WEST SUSSEX COUNTY COUNCIL CONSULTATION

TO:	Arun District Council FAO: James Cross
FROM:	WSCC - Highway Authority
DATE:	17 September 2021
LOCATION:	Woodgate Centre Oak Tree Lane Chichester PO20 3GU
SUBJECT:	AL/107/21/PL Demolition of the Woodgate Centre buildings (including 3 No. residential dwellings) and the construction of 180 No. residential dwellings with the creation of new vehicular access with footways and cycleways, ancillary road infrastructure, emergency access arrangements, associated parking, public open space, including children's play space, landscape planting, surface water attenuation and drainage and other associated infrastructure. This site is in Cil Zone H SP2, BEW Strategic Site and is not CIL Liable.
DATE OF SITE VISIT:	10 th September 2021
RECOMMENDATION:	More Information Required
S106 CONTRIBUTION TOTAL:	£ See below for breakdown

Drawing No.	Rev.	Title	Description	Scale
20-061-014	B	Land East of Woodgate Lane	Proposed Site Access and Cycle Connection	1:1000 @ A3

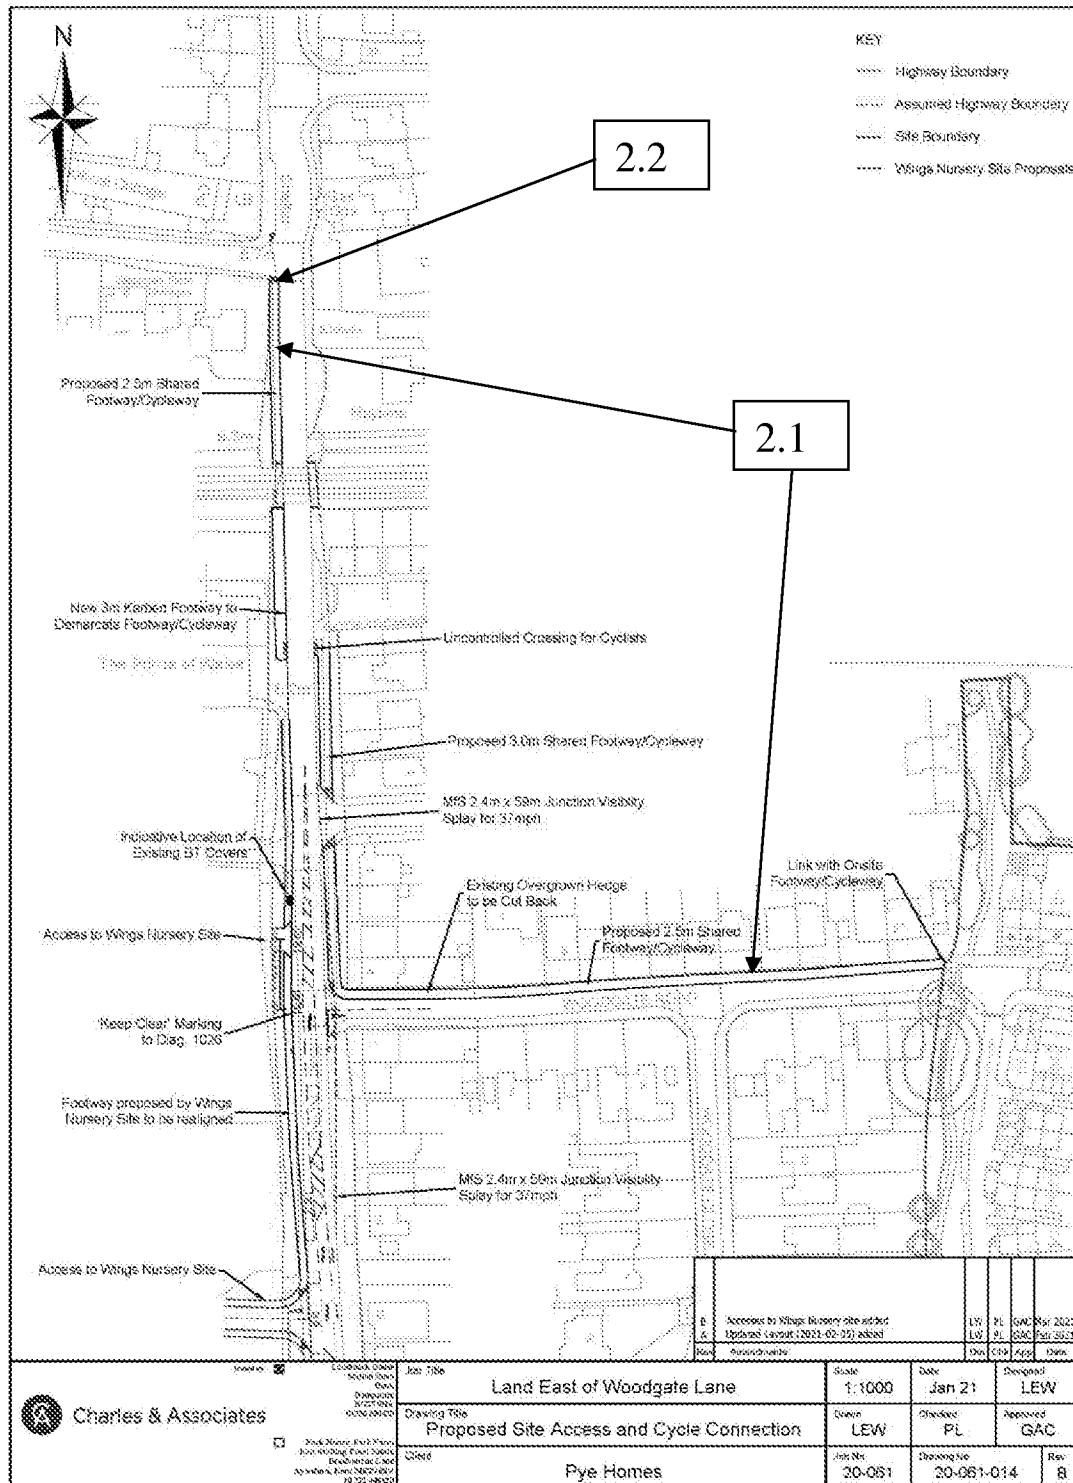
Additional to this are shared foot and cycle paths – one section along the northern-side of Woodgate Road and then continuing northwards along the A29 – firstly along the eastern-side of the road and then along the western side, terminating just before the junction with Hook Lane found north of the railway crossing (shown on submitted drawing 20-061-014 Revision 'E').

With regard to the changes shown, the applicant should provide further information to demonstrate how such works comply with the relevant sections of DMRB (for the road works) and for the cycle works, LTN 1/20. Specifically with regard to the widened footway (to provide shared use – foot and cycle) along the northern-side of Woodgate Road, the applicant should explain how this is achieved (i.e. does it require any narrowing of the existing carriageway of Woodgate Road or is it wholly accommodated within the existing footway and verge running along that side of the road)?

The applicant should note that the realignment of the footway on the western side of the A29 to cater for the increased width for the right turn lane in to Woodgate Road might have an impact upon the existing ditch and new culverts that are part of the Wings Nursery design. If approved, the applicant (of the Woodgate Centre) would need to meet the costs of all the necessary changes.

The audit team noted that the proposed shared-use cycle facilities are shown to be 2.5m-wide instead of the recommended 3.0m as-per current national standards. They consider that the sub-standard width could lead to cycle/pedestrian collisions.

The audit team noted that the proposed cycle facility ends at the Lidsey Road/Hook Lane junction and there is no indication of how cycles would re-join the carriageway. Northbound cyclists would have very poor visibility at the Hook Lane junction due to no footway on the south-side and leaving the shared-use facility to the carriageway may lead to vehicle/cycle collisions.

The Design Organisation should reply to the above. And, a plan should be submitted showing the revisions documented above.

Appendix I Internal Layout Review Plan

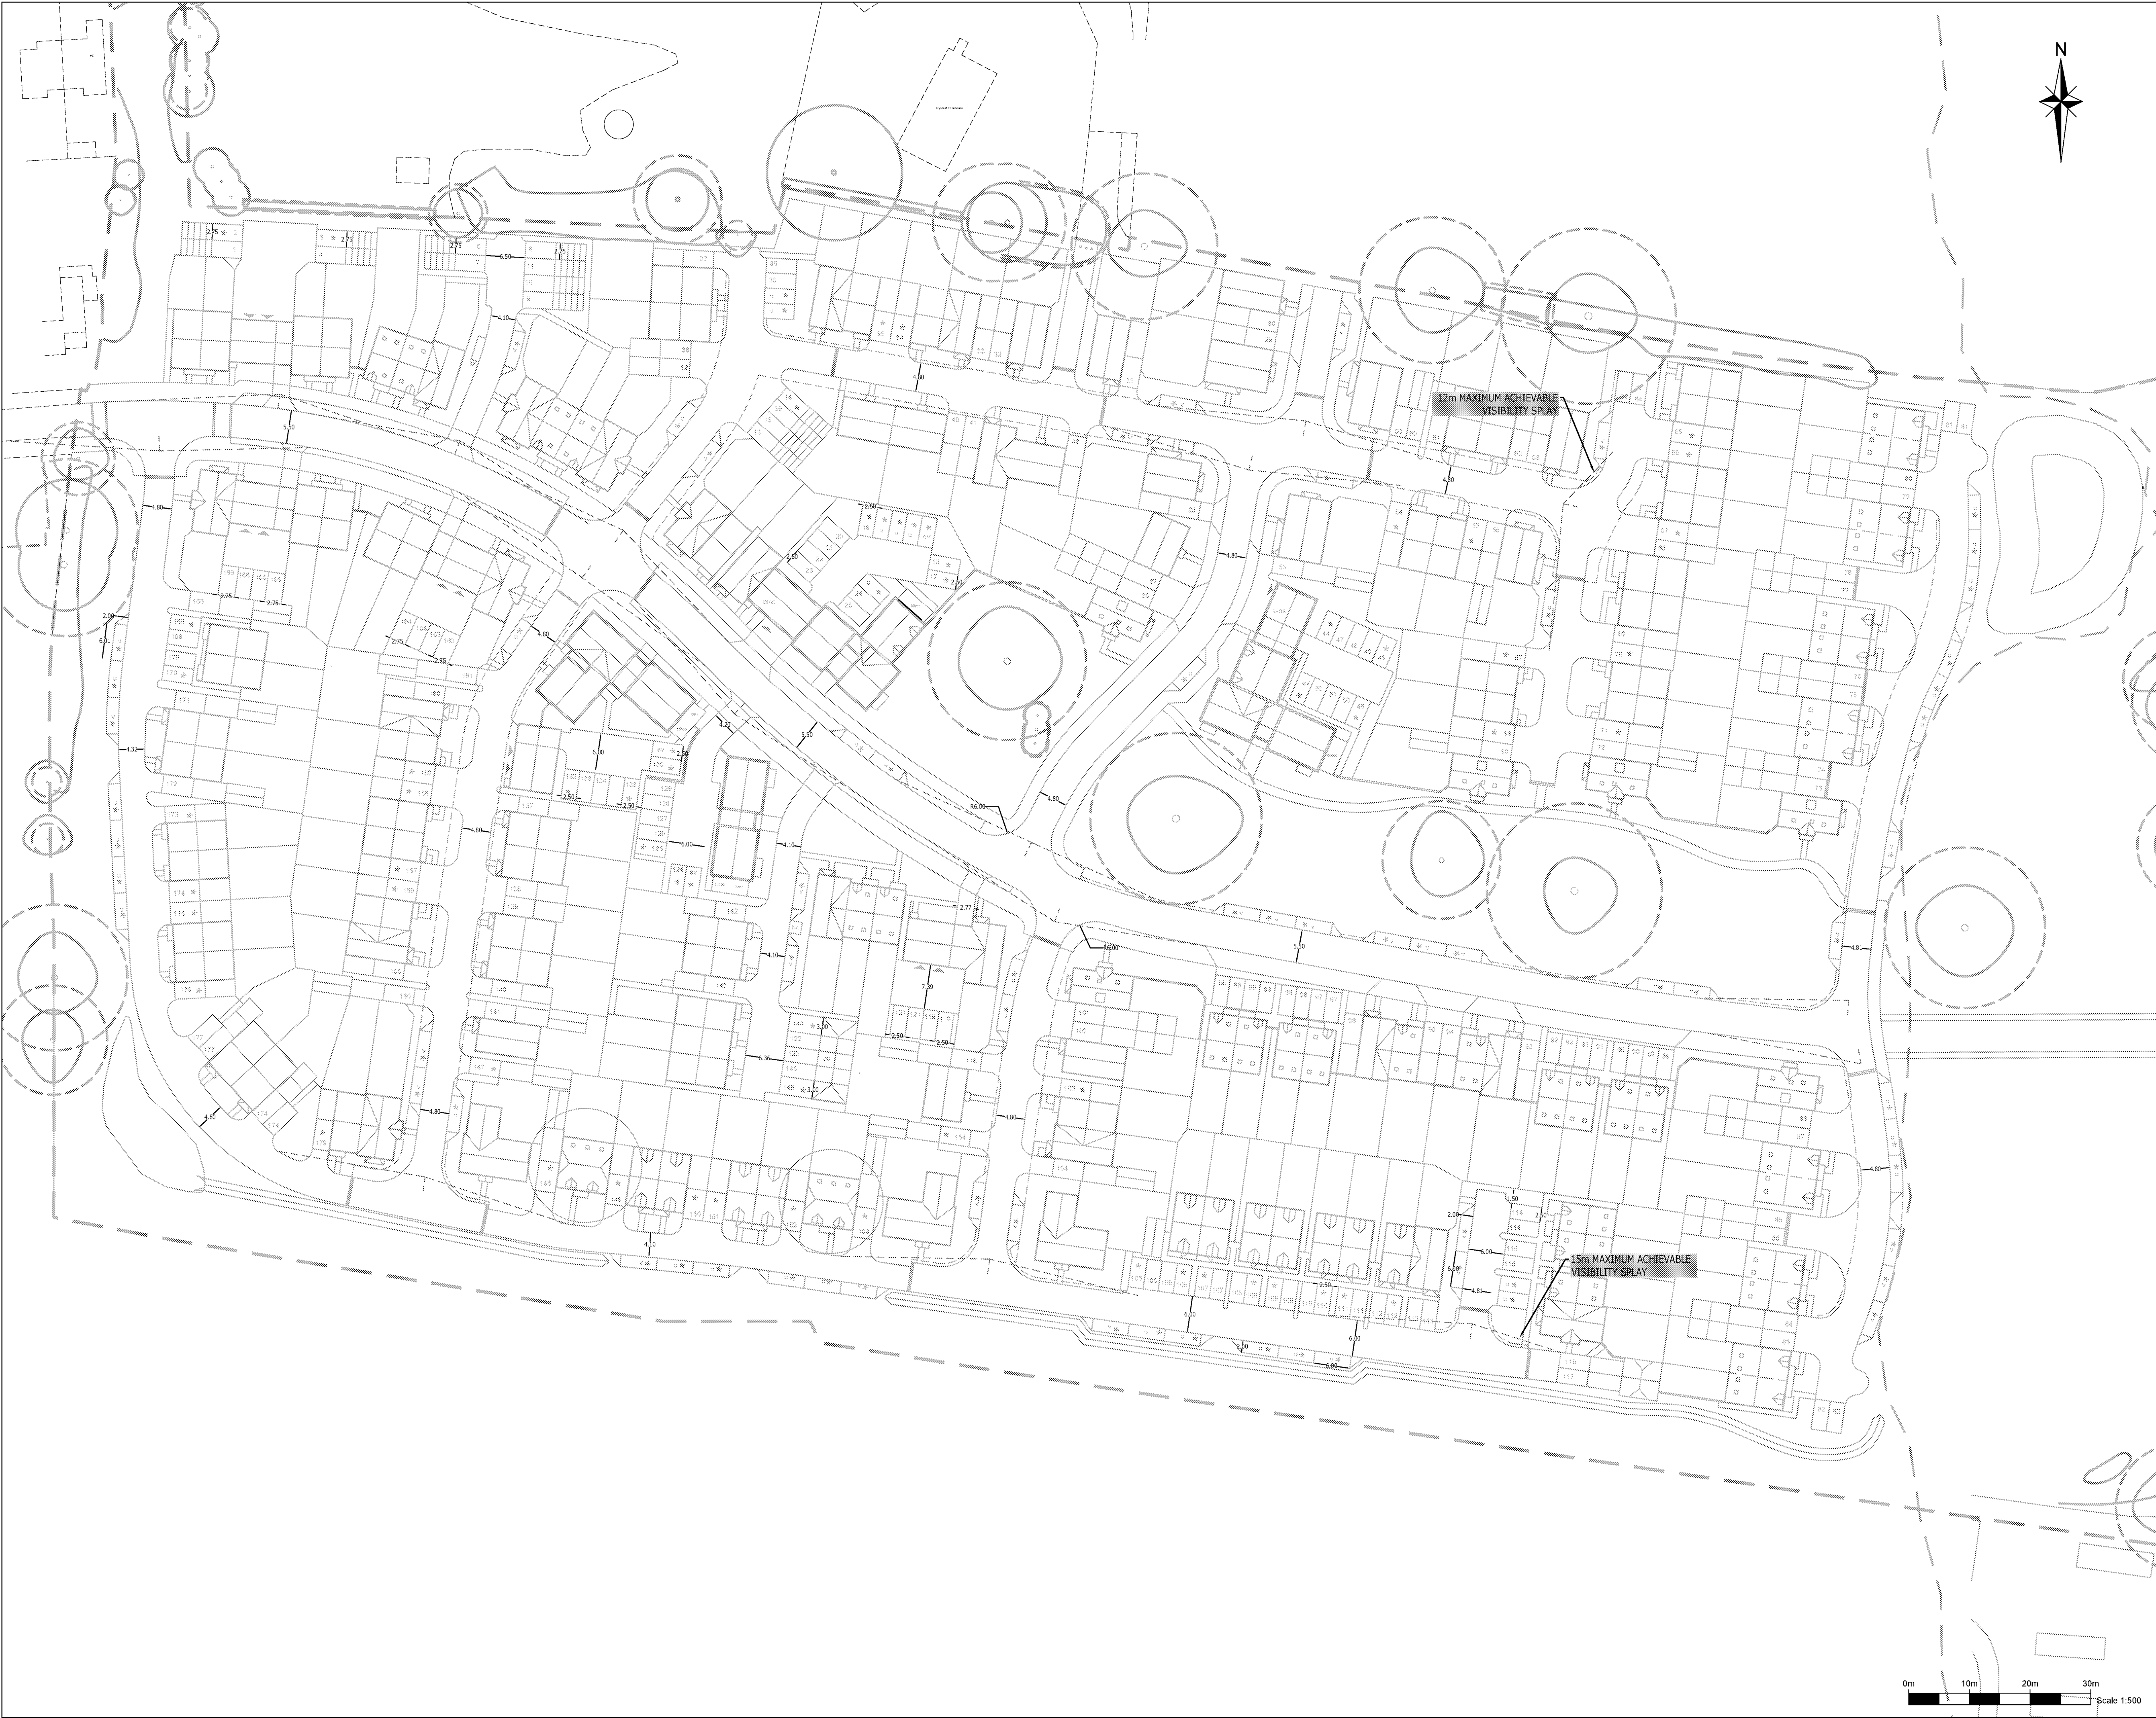
From scrutiny of the plans provided for the internal layout, it is apparent that at some junctions on the main 'spine road' running E-W through the development that raised table features might be offered. Given the relative straightness of the alignment of the roads, this form of traffic management should be provided at each junction along the spine road.

In addition to the above, where traditional roads with footways become shared-surface roads, the tie-ins for the footways should be further into the shared surface roads.

For the shared foot/cycleway running through the site using the alignment of the spine road – initially on the northern-side but then transferring to the southern-side, the current arrangement would require cyclists to give-way to drivers at the junctions.

Where appropriate to do so, LTN 1/20 does encourages designers to design for cyclists and pedestrians having priority at junctions. Looking at the current plans, this would require amendments to the internal layout to enable this. While it might be difficult to achieve such an arrangement for those crossing N-S across the spine road as they enter or leave the site, the designer might be able to consider the side road junctions as such if an appropriate set-back can be achieved in-line with the LTN.

With regard to the internal paths shown running-around the boundary of the development (internal to the site) and that shown running north to Oak Tree Lane and land to the north, the applicant should show how these would be suitable for foot and cycle access.

A plan showing all the above to be provided. For any changes to the junction priorities for pedestrians and cyclists, the applicant should run these past the Road Safety Audit team for comments.
